Our ref: AE/2022/127023/03-L01
Your ref: -
Date: 16 August 2022

APPLICATION BY LONGFIELD SOLAR ENERGY FARM LTD FOR AN ORDER GRANTING DEVELOPMENT CONSENT FOR THE LONGFIELD SOLAR FARM (EN010118) - RESPONSE TO DEADLINE 1B - WRITTEN REPRESENTATION LONGFIELD SOLAR FARM

**Figure 1: Fluvial Flood Zones including indicative concept design (Figure 9-2b [EN010118/APP/6.3])**

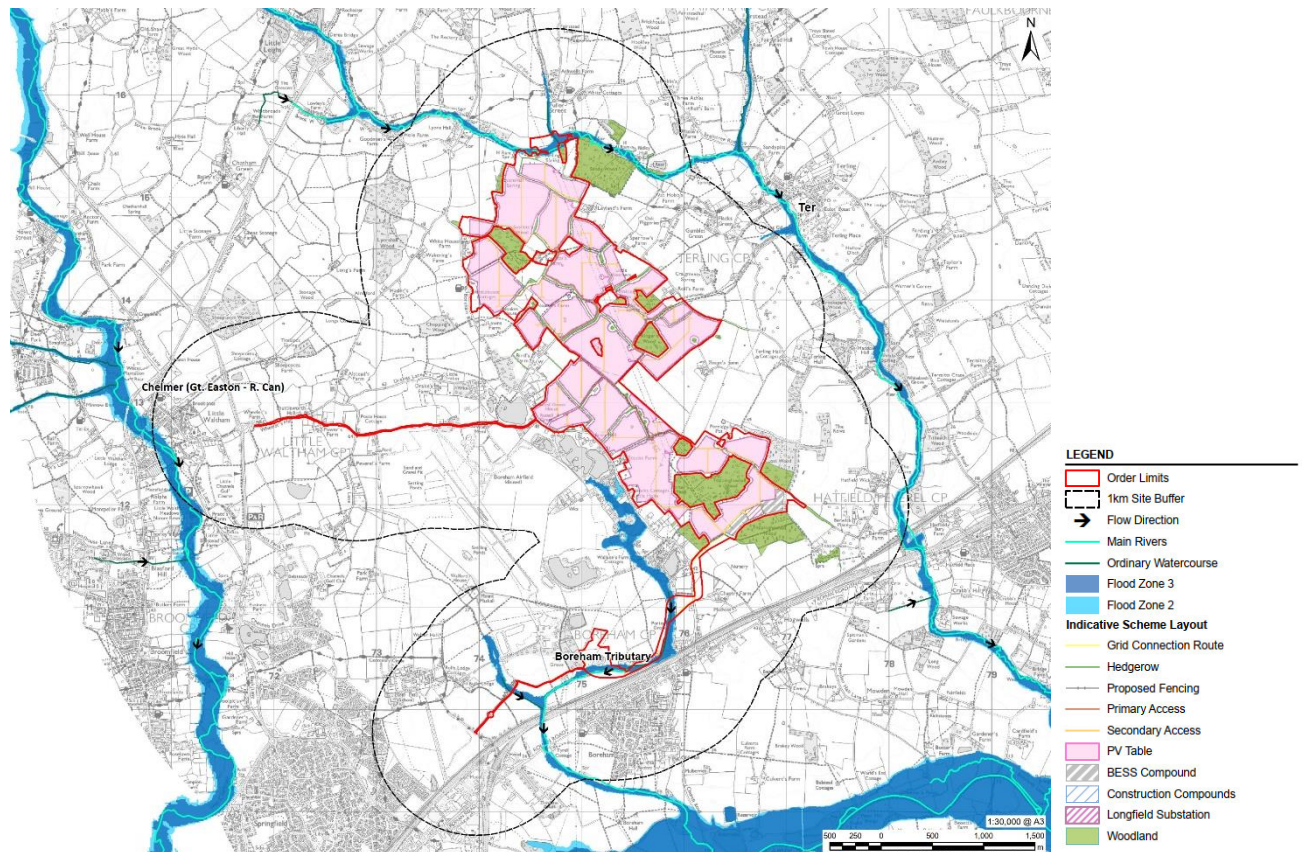
In our response to the statutory consultation dated 25 May 2022 and referenced AE/2022/127023/01-L01, we provided our position on Flood Risk. We identified that the applicant had not undertaken site specific hydraulic modelling of the River Ter and Boreham Brook (tributary) but have instead used the Braintree SFRA outlines to define the fluvial Flood Zones. We outlined two options for the applicant to explore:

1. Undertake site specific hydraulic modelling of the River Ter and Boreham Brook (tributary) .
Or
2. Assess that there is no 'critical infrastructure' within Flood Zones 2 or 3 or ideally that critical infrastructure is outside the 0.1% (1 in 1000) annual probability event with allowance for future climate change (maximum credible scenario).

We are pleased to see that the applicant has now provided further information to us that shows the PV solar panels would not be affected by floodwaters as they are raised. The Flood Zones depicted in the SFRA's are an over estimation compared with the latest requirements for climate change, even the maximum credible scenario (Upper End) of 37%. Therefore, we are satisfied that there are no features of the infrastructure that are critical to its operation close to the boundaries of the flood zones and therefore flood risk modelling will not need to be undertaken.
